RE: Transmittal of Comments – 3160 VIA Kachess Shoreline Variance application (SV-14-00001)

TO: Lindsey Ozbolt
FROM: Christina Wollman, Planner III *CW*
DATE: May 2, 2014
SUBJECT: 3160 Via Kachess Shoreline Variance SV-14-00001

Sheet Title
SITE PLAN
SCHEMATIC

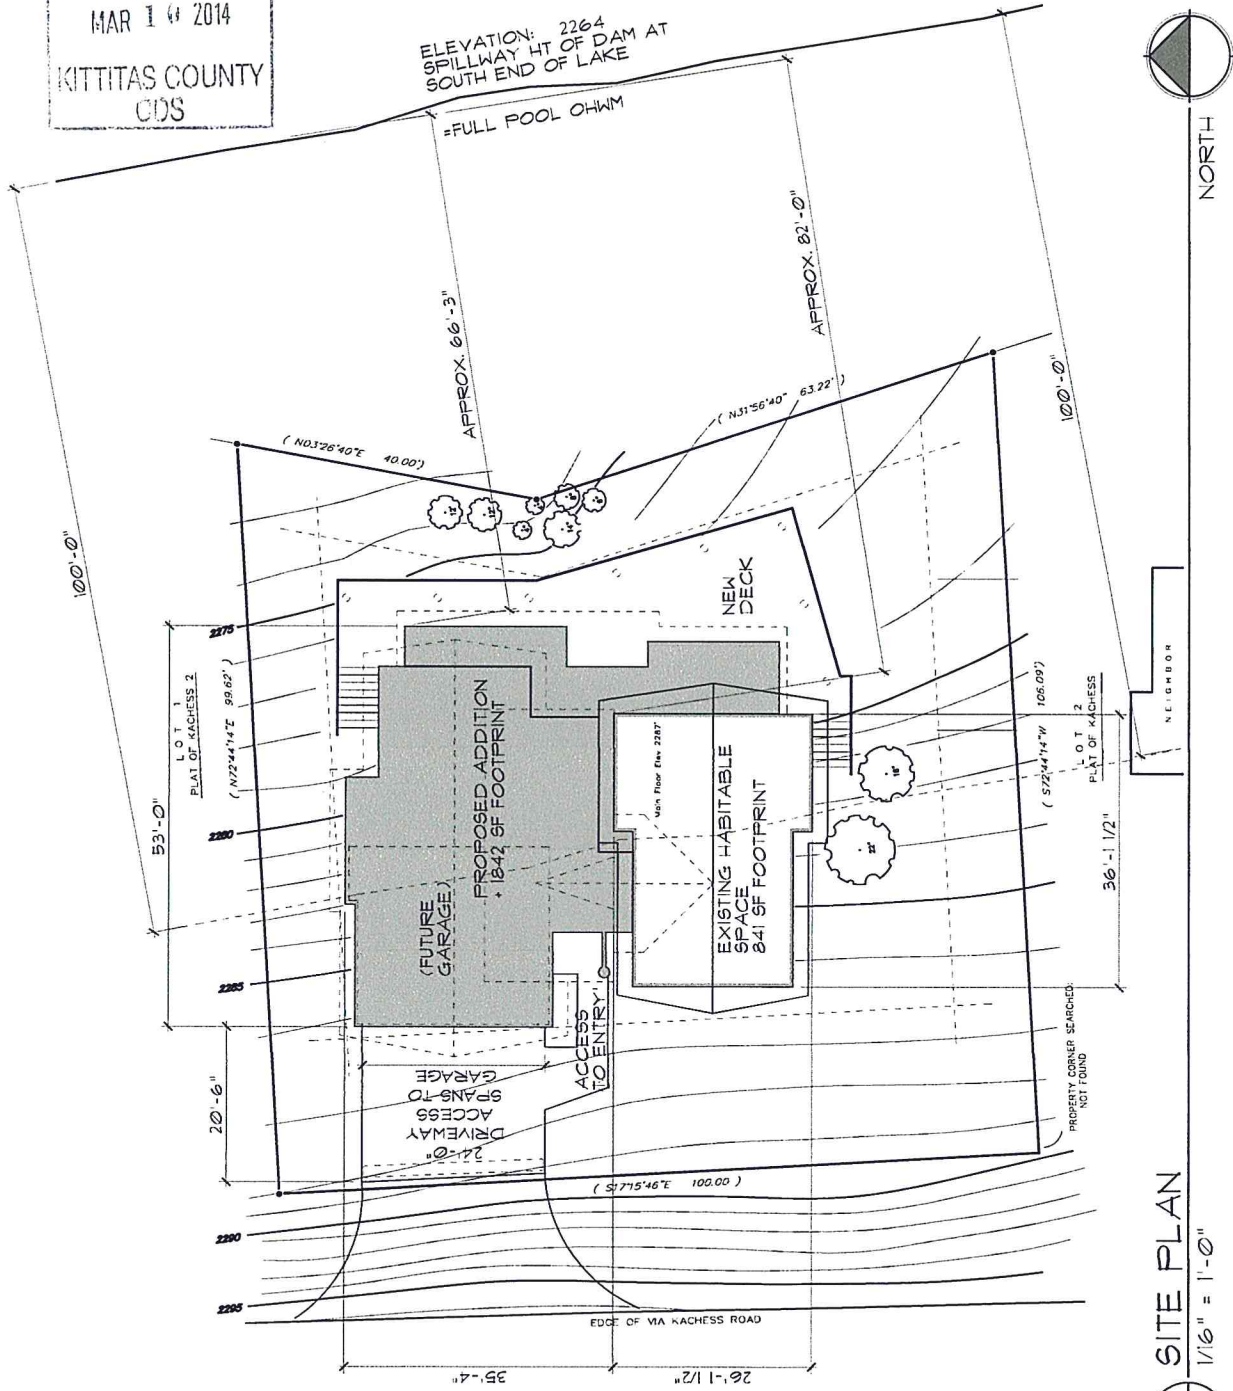
- B. Access: This project proposes a new access from the county road. An access permit must be applied for and issued prior to beginning any work within the county right of way. Access must be completed prior to issuance of a building permit.

However, as I mentioned in the previous emails an access permit will be required. Due to the complexity of the proposal, review and approval by the county engineer will be required and this process is suggested to be started as soon as possible. You will not be able to be issued the building permit until the access design is approved and the access is either completed or bonded for.

And one more thing I should mention is the use of the county right of way during construction. Space is very limited at your site and you may need to block a lane of traffic at times or use the shoulder as a materials staging site. If this is the case, you or your contractor will need to apply for a work in the right of way permit from Public Works and provide a traffic control plan.

1. Appears you did not realize that the US Government owns land, managed by the United States Forest Service (USFS), between the ordinary high water level (OHWM) and the original take line. The Bu of Reclamation manages all lands up to the OHWM. The data on Lake Cle Elum shows this type of ownership. but it is not shown on your Lake Kachess map data.

The request could affect the US Government owned lands, managed by the USFS, or be in violation of required setbacks from property lines. Property corners were all in place about 20 years ago- not sure now- but it needs to be addressed for allowable setbacks from other property ownership. An educated guess would be that the applicant property line is the Government land boundary, which puts the proposal very close to the property line.
